City of Portland, Maine - Building or Use Permit Application
 389 Congress Street, 04101 Tel: (207) 874-8703, Fax: (207) 874-8716

Permit No: 03-0640 Issue Date: AUG 15 2003 CB#: 340 C021001

Part Use: Vacant Lot	Proposed Use: Single Family	Permit Fee: \$1,098.00	Cost of Work: \$100,000.00	CEO District: 1
Proposed Project Description: Construct New 46' x 28' Single Family Home GG 1045 [Signature]		FIRE DEPT: <input type="checkbox"/> Approved <input type="checkbox"/> Denied	INSPECTION: 2-3 Type: SB [Signature] Start Manufacturing Housing	
		Signature: PEDESTRIAN ACTIVITIES DISTRICT (P.A.D.) Action: <input type="checkbox"/> Approved <input type="checkbox"/> Approved w/Conditions <input type="checkbox"/> Denied Signature: Date:

RE: C. of O. for #16 Seventh Street
(CBL 340C021) (ID 2003-0125)

REVISED: 07/15/03 ~ Added 5'x8" front steps.
 REVISED: 07/16/03 ~ Added proposed contours, driveway and service connections.
MINOR SITE PLAN
 FOR A SINGLE FAMILY HOME
 ON SEVENTH STREET, PORTLAND, MAINE
 FOR:
MARY C. MCCARTHY

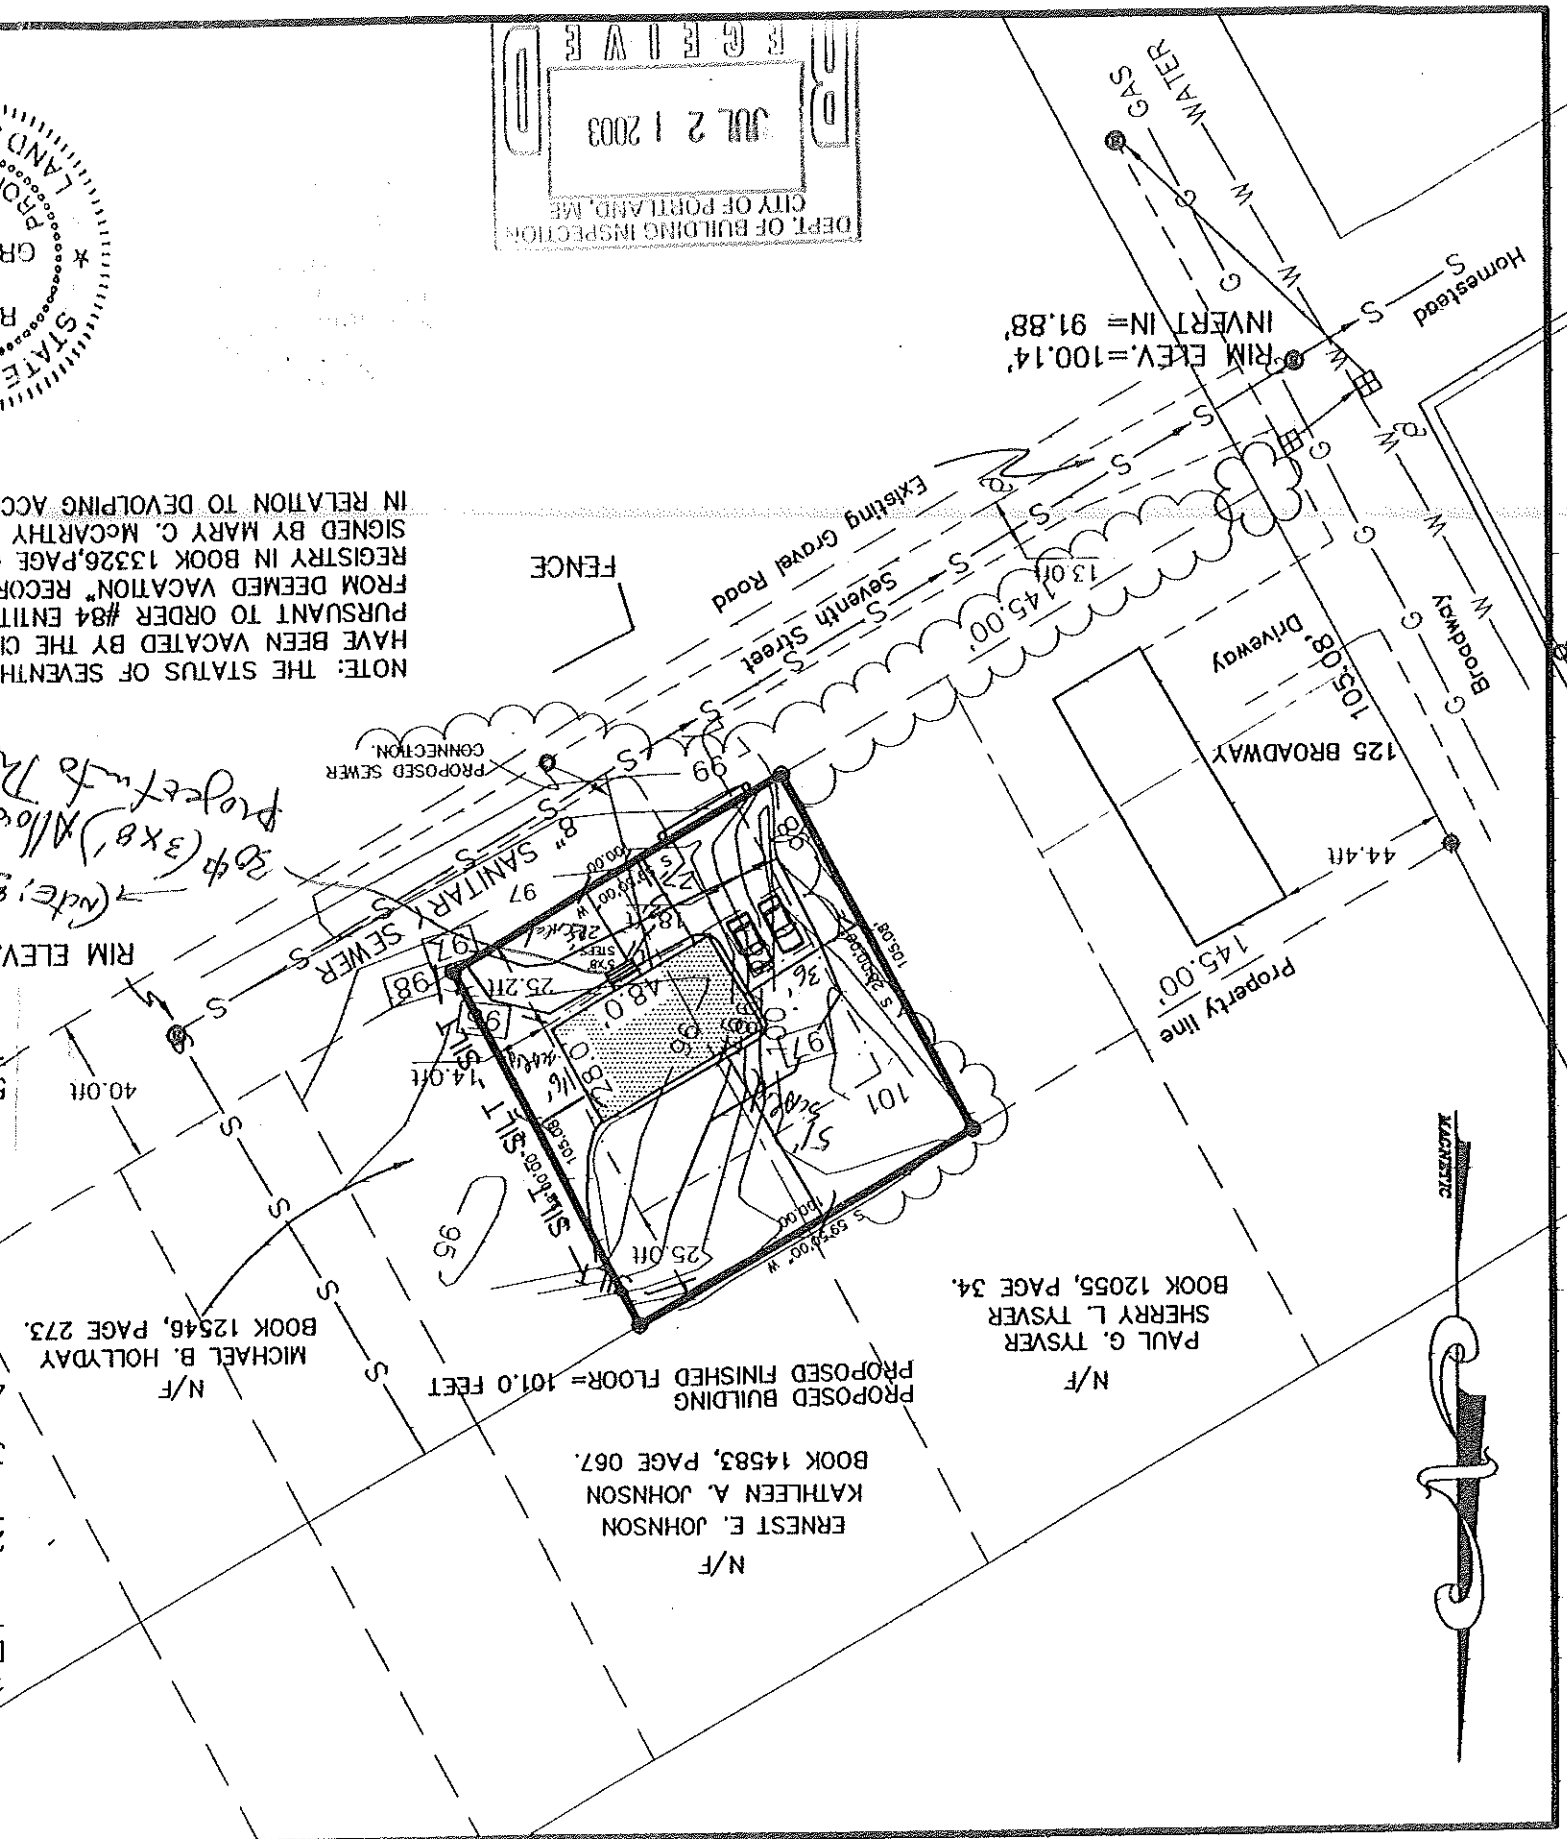
Note: 6/24/03 requested a revised site plan showing two parking spaces and front steps - also advised Karen that there was no logging in of minor/minor site plan review (she inputted the information) Ok to Issue:

- 7/16/03 - dropped off new plans - only shows parking - I requested to see the front steps also
- 7/21/03 - received revised plans with parking and front steps
- 1) There is a daylight basement shown on rear. Zoning was approved with daylight basement.
- 2) Separate permits shall be required for future decks, sheds, pools, and/or garages.
- 3) This permit is being approved on the basis of plans submitted. Any deviations shall require a separate approval before starting that work.

7/16/2003-gg: Received revised site plan requested by Marge. /gg
